Householder Proforma

Application Ref: 2021/1442
Address: 17 Medway Close, Barugh Green, Barnsley, S75 1NY
Neighbour Representations: No
Property Description: the red brick detached dwelling is located in a purely residential area of similar styled properties.
The dwelling is located at the head of a cul-de-sac and occupies a triangular plot

Proposed Extension: Erection of two storey side extension to dwelling

Proposed Front Elevation

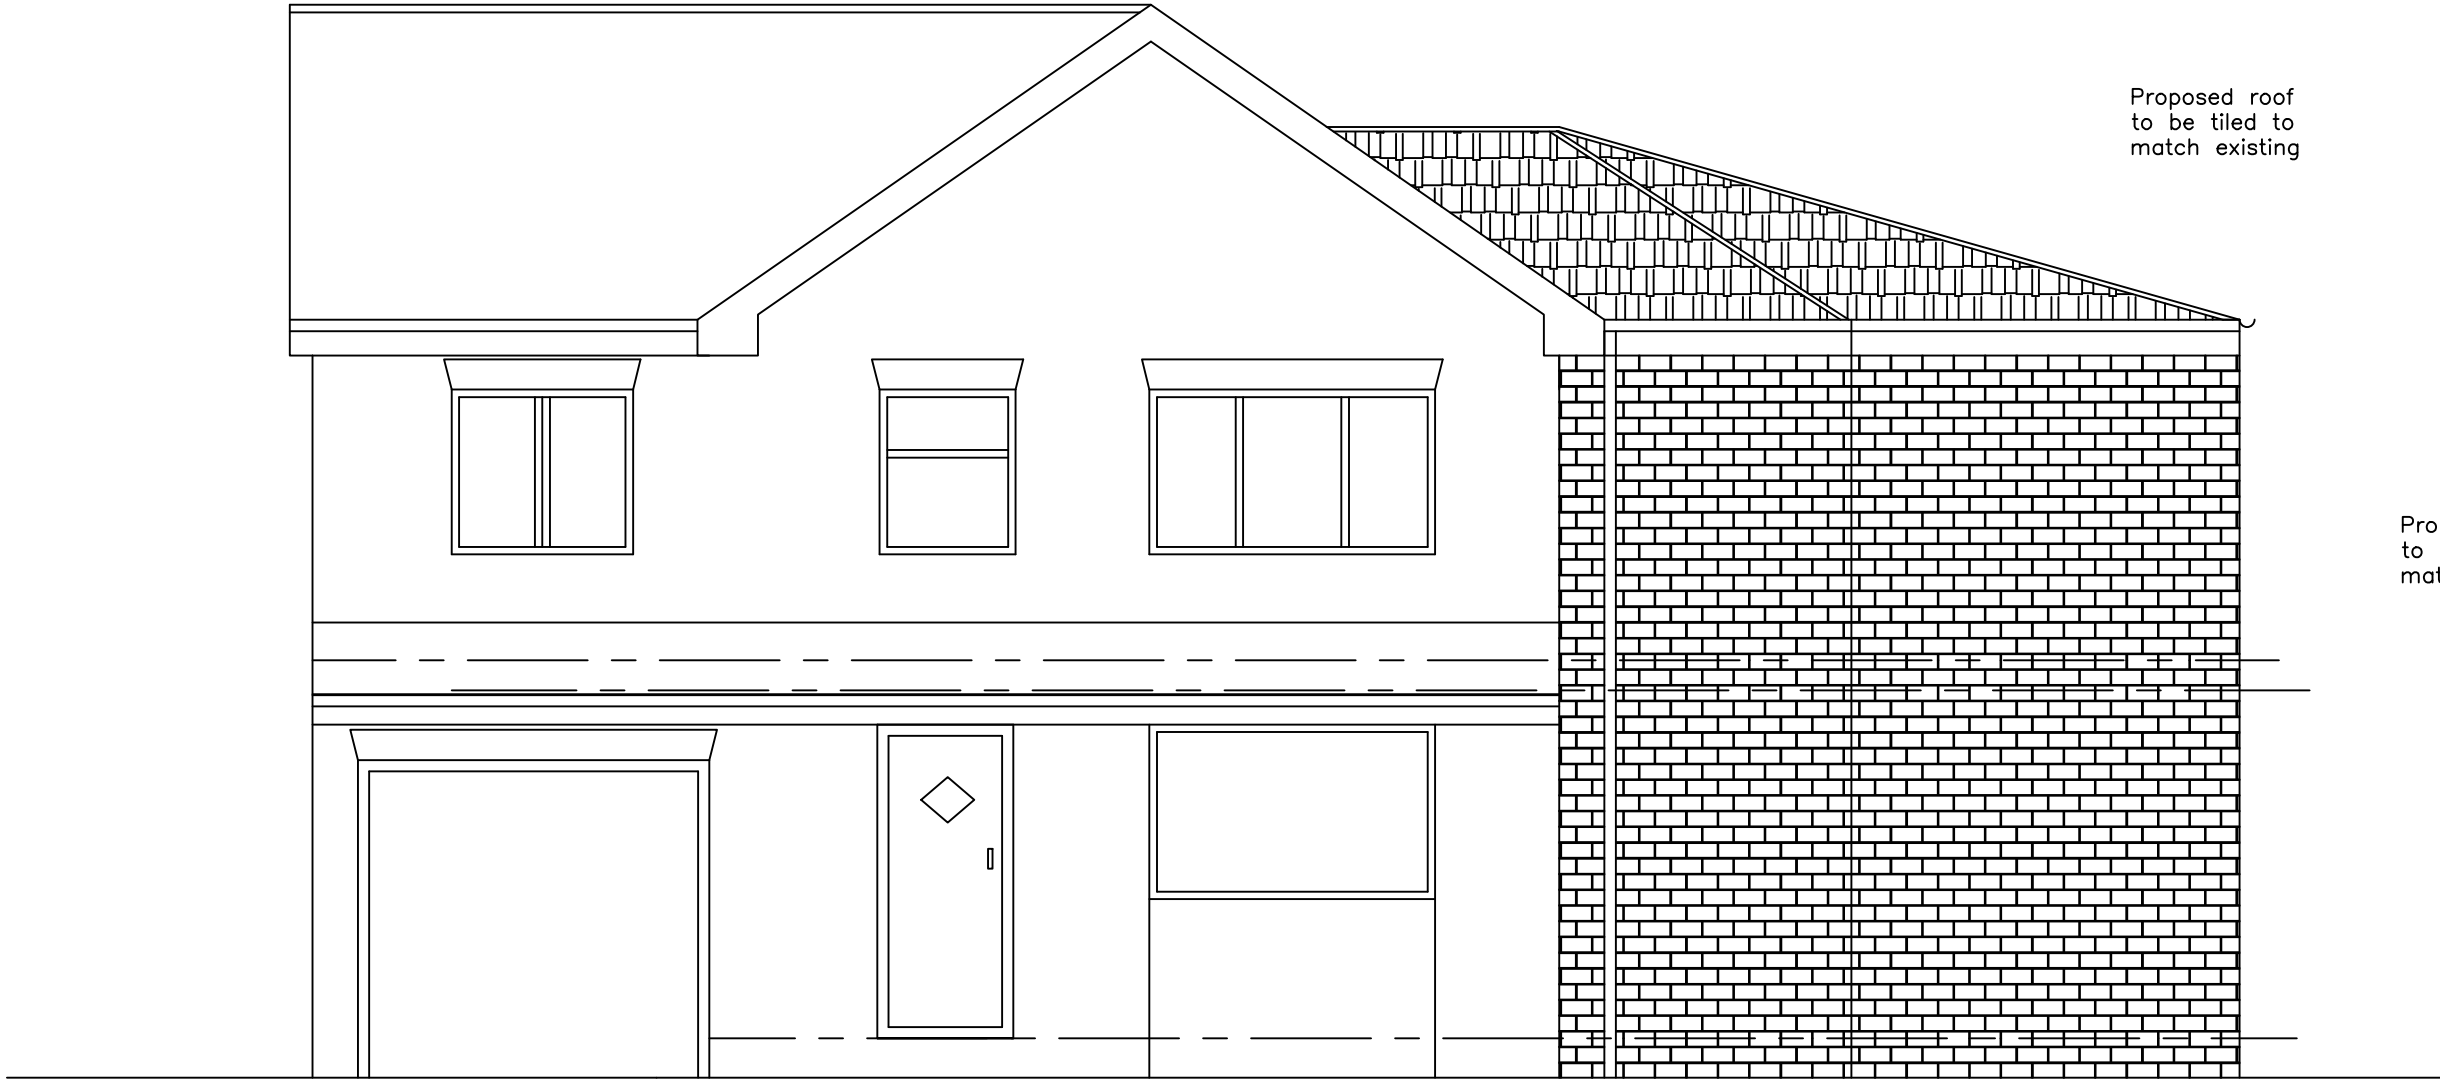
The extension is to be set back from the front elevation of the dwelling by approximately 3.1m, which allows for a lowering of the ridge of the extension.

The dwelling benefits from a two storey side extension to the southern elevation which was approved in 2000, therefore the width of the original dwelling is approximately 5.4m, which would result in an extension with a maximum width of 3.6m, however, given the shape of the plot the extension is designed narrower at the front elevation and on balance due to the location of the dwelling and the significant set back of the extension it is considered that the increased width at the rear elevation would not have a detrimental impact on the character of the street scene nor unbalance the existing dwelling.

Proposed Ground Floor Plan

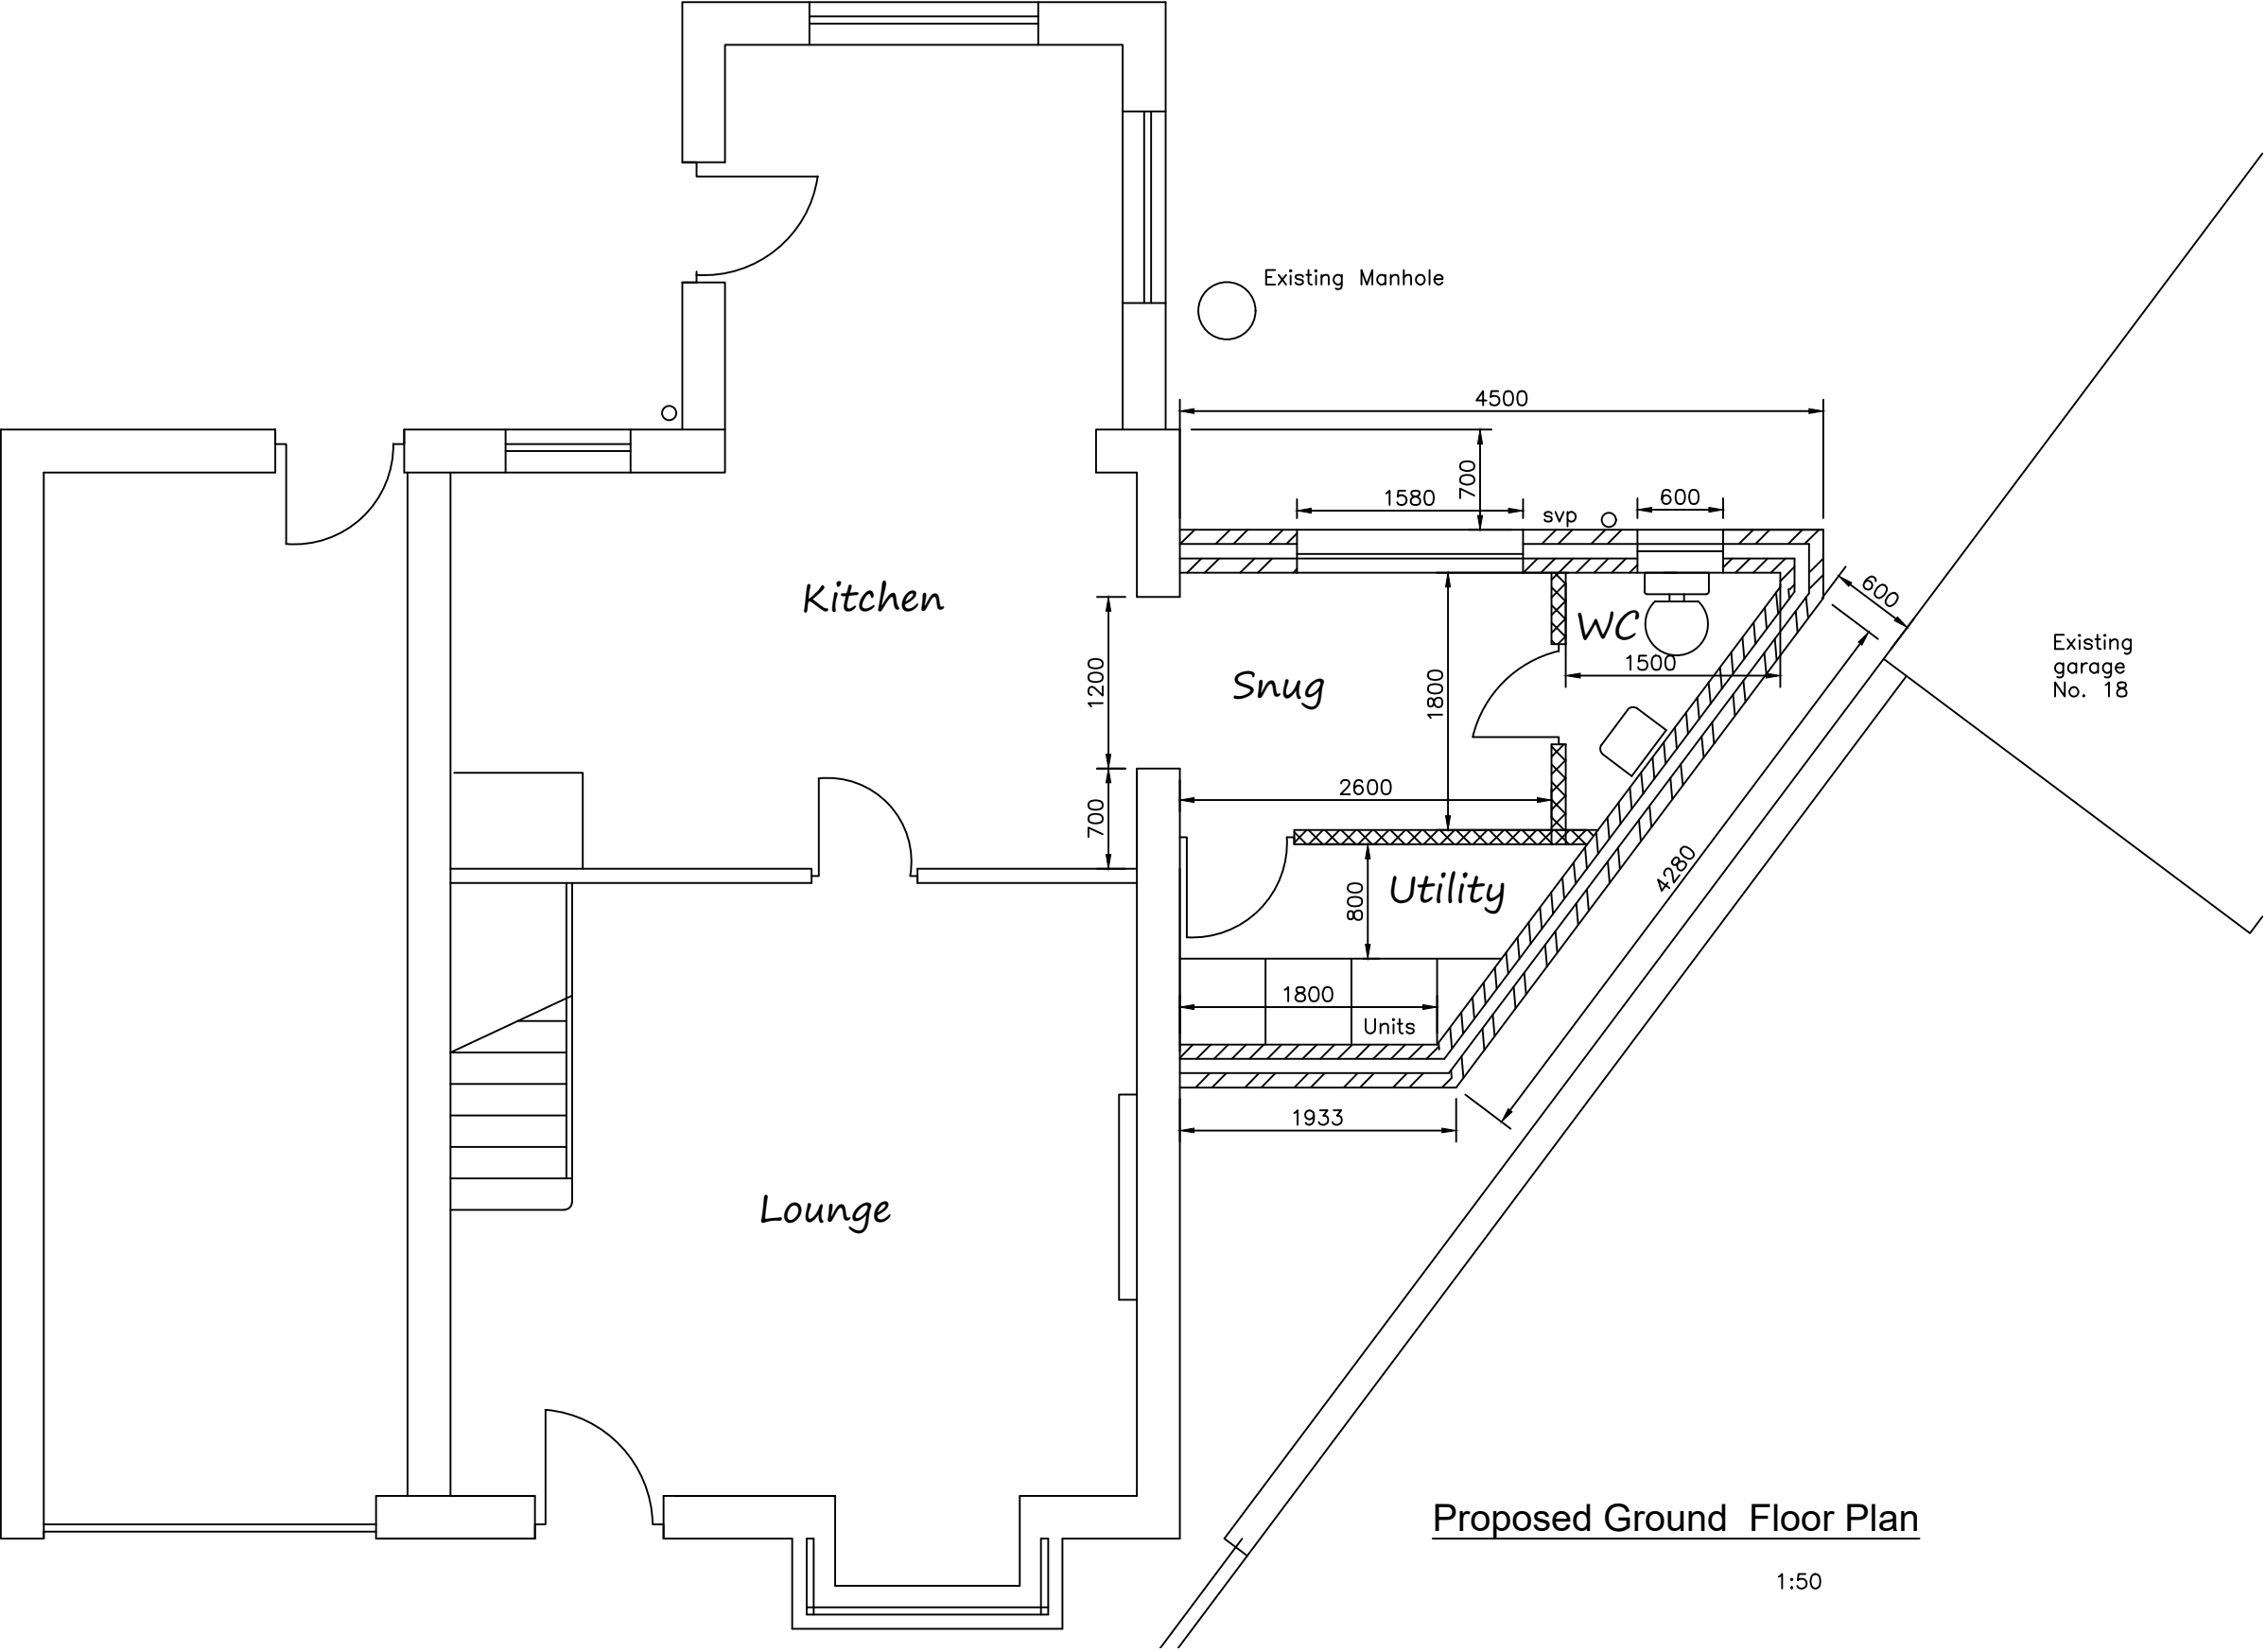
The applicant seeks permission for the erection of a two storey side extension projecting between 1.9m at the front and 4.5m at the rear elevation.

Proposed Side Elevation

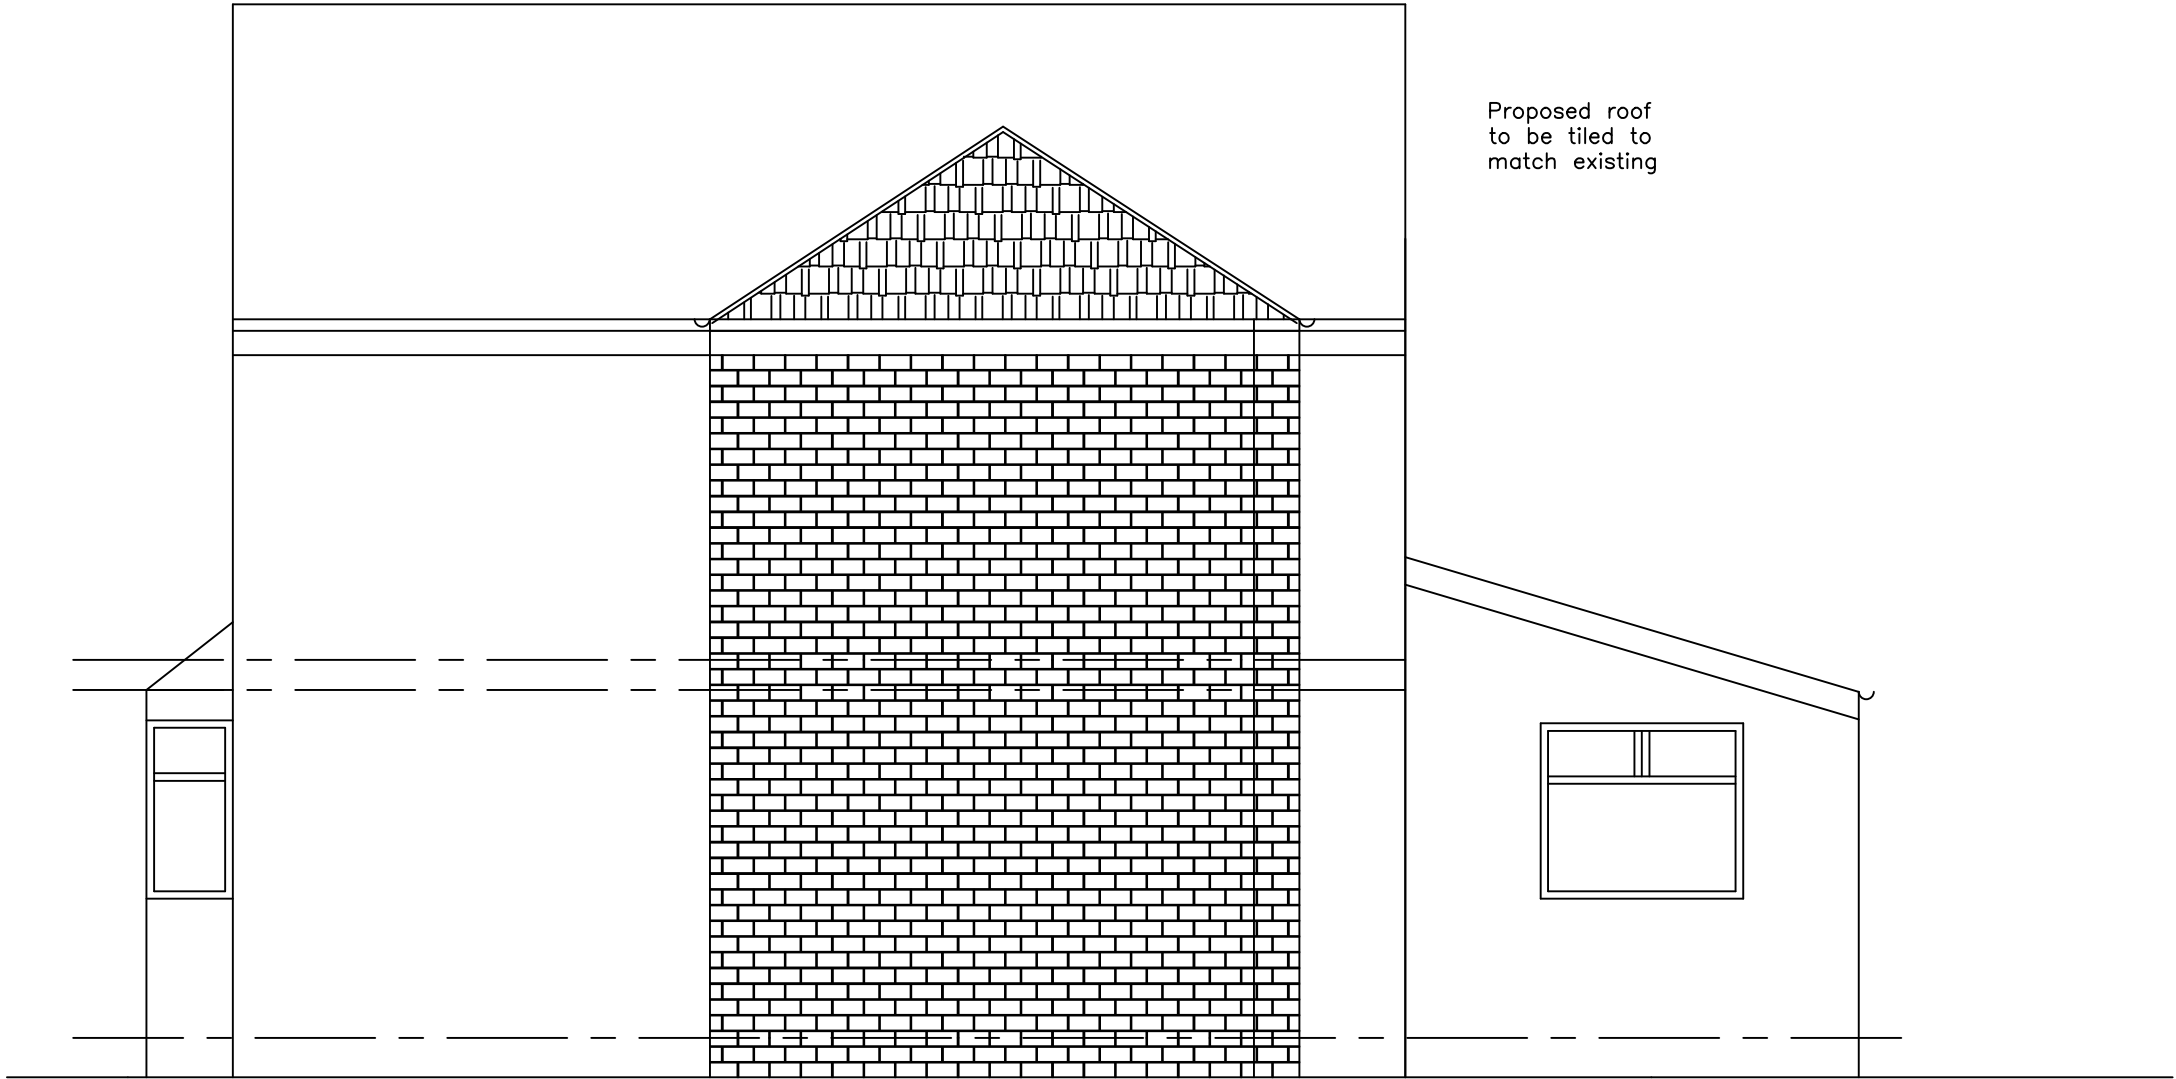
There are no windows on the side elevation of the proposed extension nor are there any on the side elevation of the neighbouring dwelling.
